10 November 2013

GREGORY BARLOW
430 ABERCROMBIE ST
DARLINGTON 2008

***Modification Request for the University of Sydney Abercrombie Precinct
Redevelopment: Application Number: MP07_0158 MOD 3***

Ground Floor Plan
1:200@A1
11.10.13
4001_DA02-D

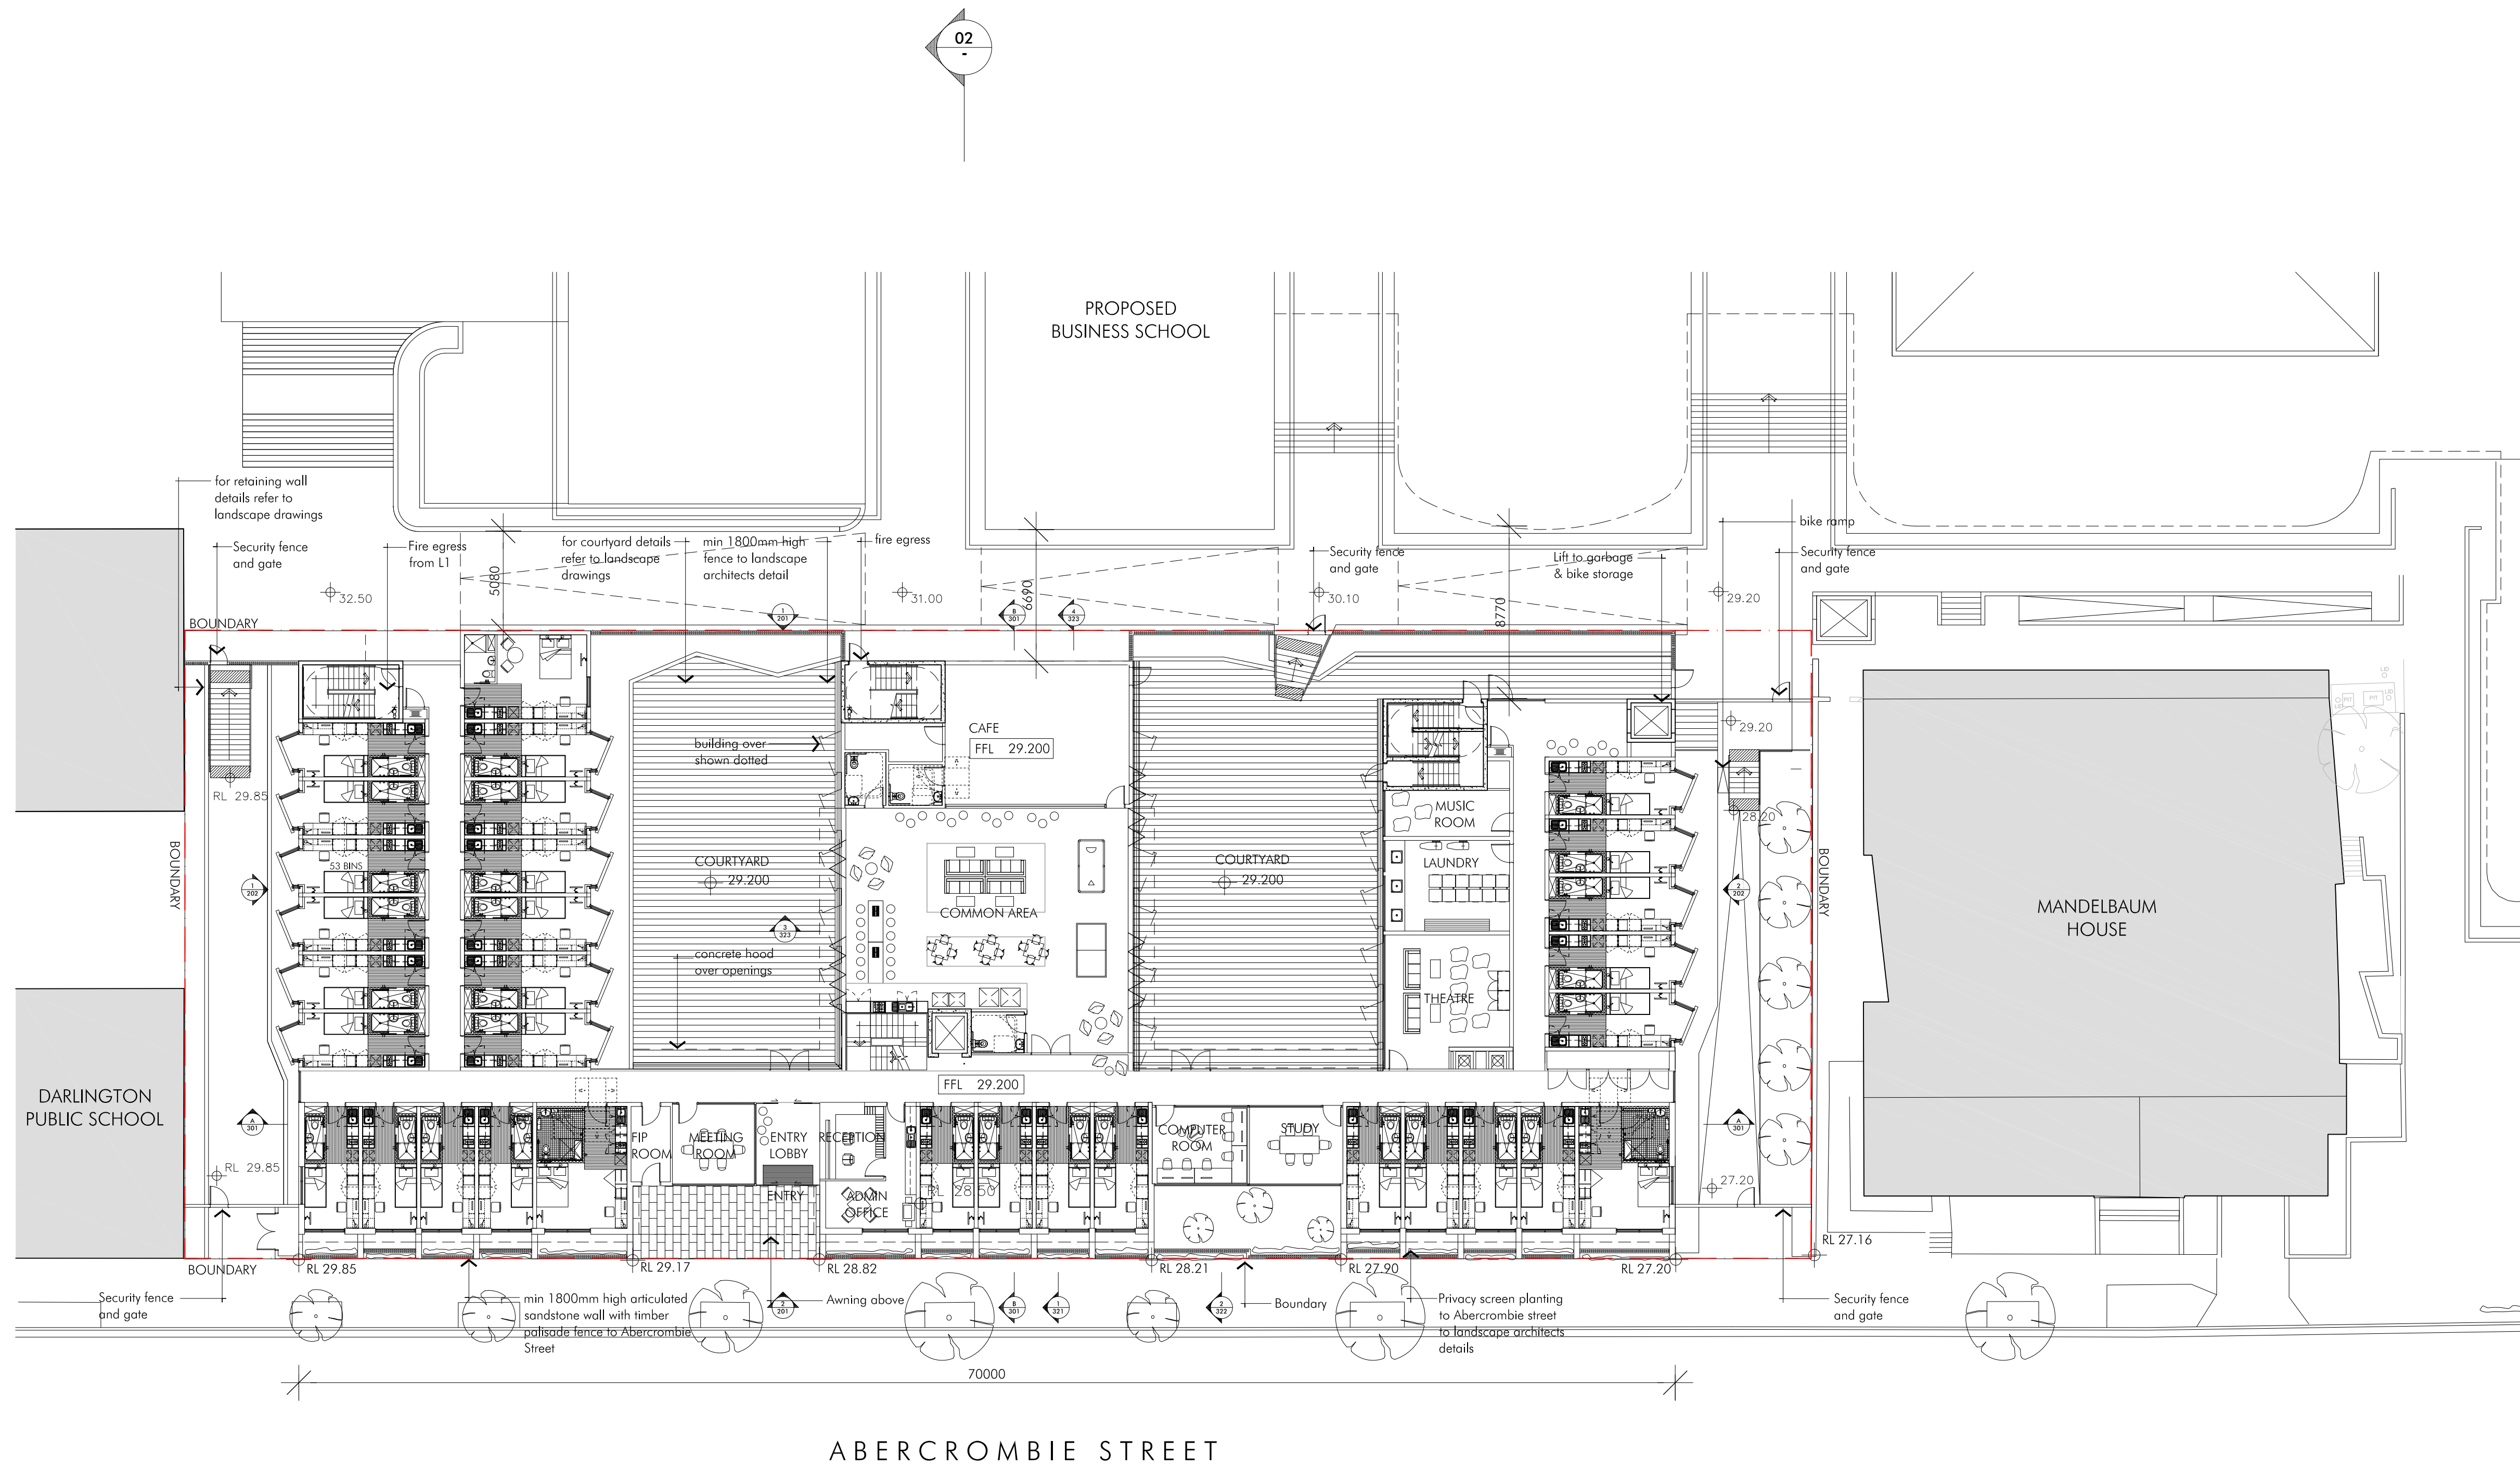
- The front of the Student Accommodation building should be built 2 metres back from the Abercrombie Street boundary. It should be set back from this boundary so that it is in line with Mandelbaum House as it was originally planned and presented to the community. The footprint of the buildings currently on the site, The Shepherd Centre and Boundary Lane Children's Centre, is approximately 2 metres back from the Abercrombie Street boundary and aligns with Mandelbaum House. Therefore, the front footprint of the proposed Student Accommodation building should be the same as those buildings currently occupying the site and as originally planned. The footprint of the proposed Student Accommodation building should not extend to the Abercrombie Street boundary.

- The facade of the proposed Student Accommodation building does not reflect the heritage appearance of the Victorian terraces opposite on Abercrombie Street as Mandelbaum House does. Therefore, it should be set back to allow for extensive vegetation and trees to be planted in front of the building on Abercrombie Street to help preserve the heritage streetscape and improve both the aesthetics and the environment of the street.
